Addendum No. 1

RE: Contract # C203976

Montgomery-Moore County (B-5362)

Bridge #53 Over Drowning Creek On NC-73

**PAVEMENT MARKING  
DETAIL**

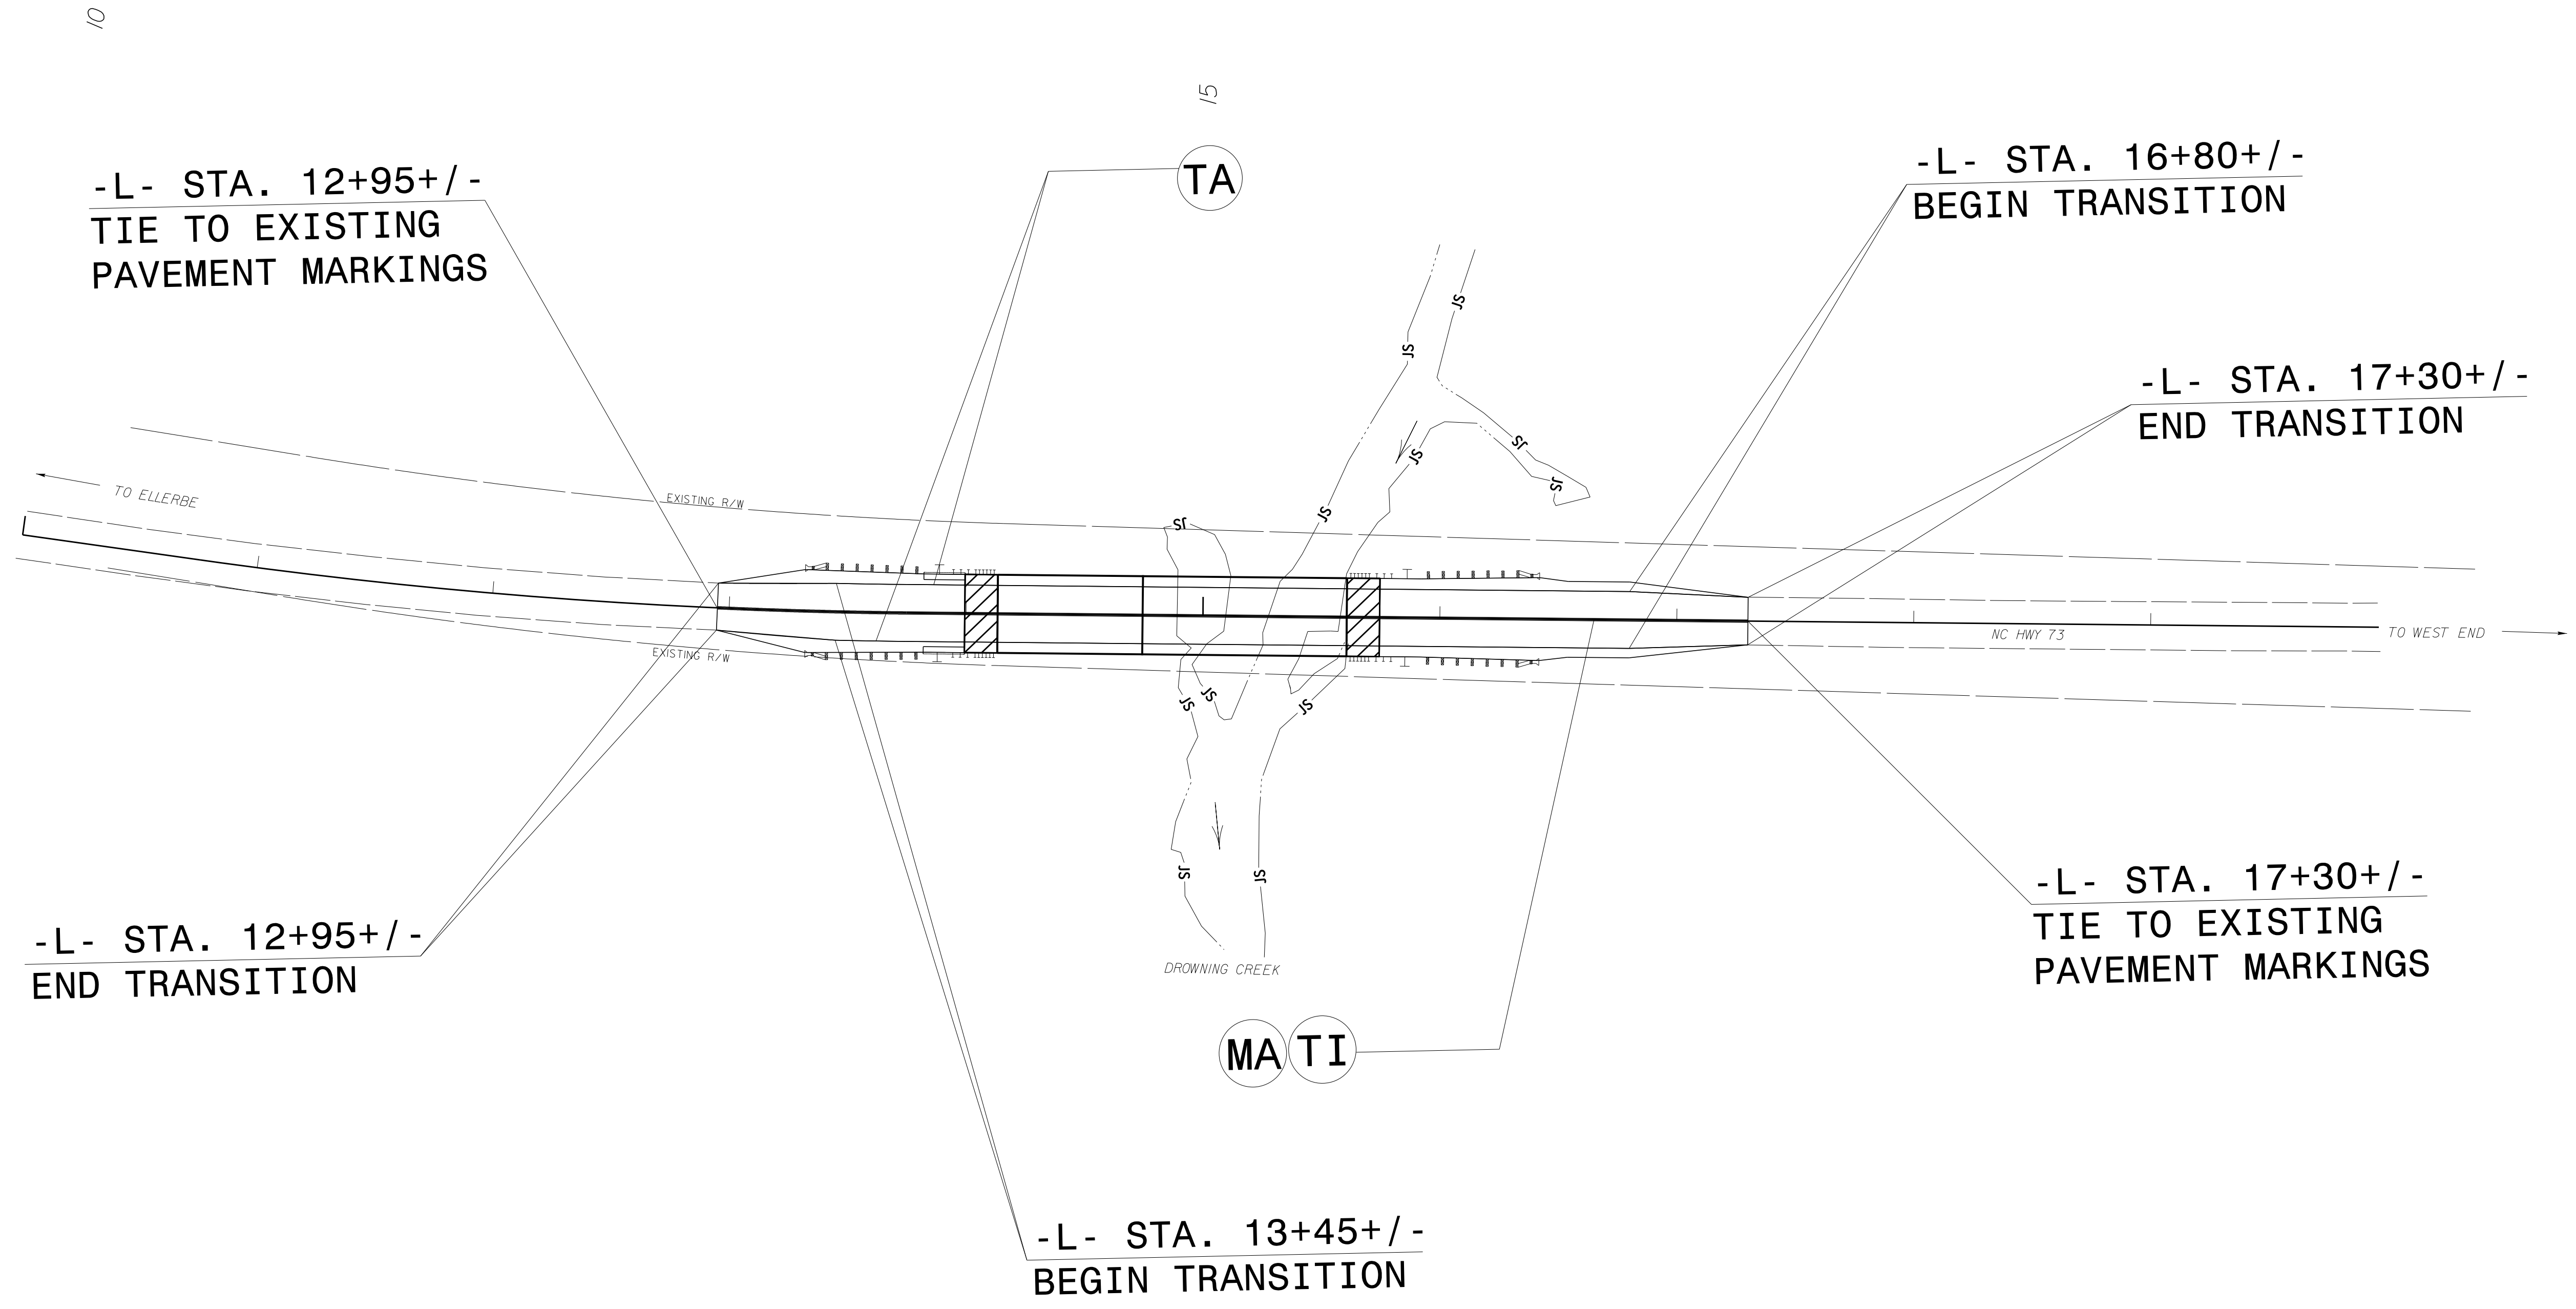
On the item sheets the following pay item quantity has been revised:

<u>Item</u>	<u>Description</u>	<u>Old Quantity</u>	<u>New Quantity</u>
036-468500000-E- 1205	Thermoplastic Pavement Marking Lines (4", 90 Mills)	435 LF	870 LF

The Contractor's bid must be based on this revised pay item quantity.
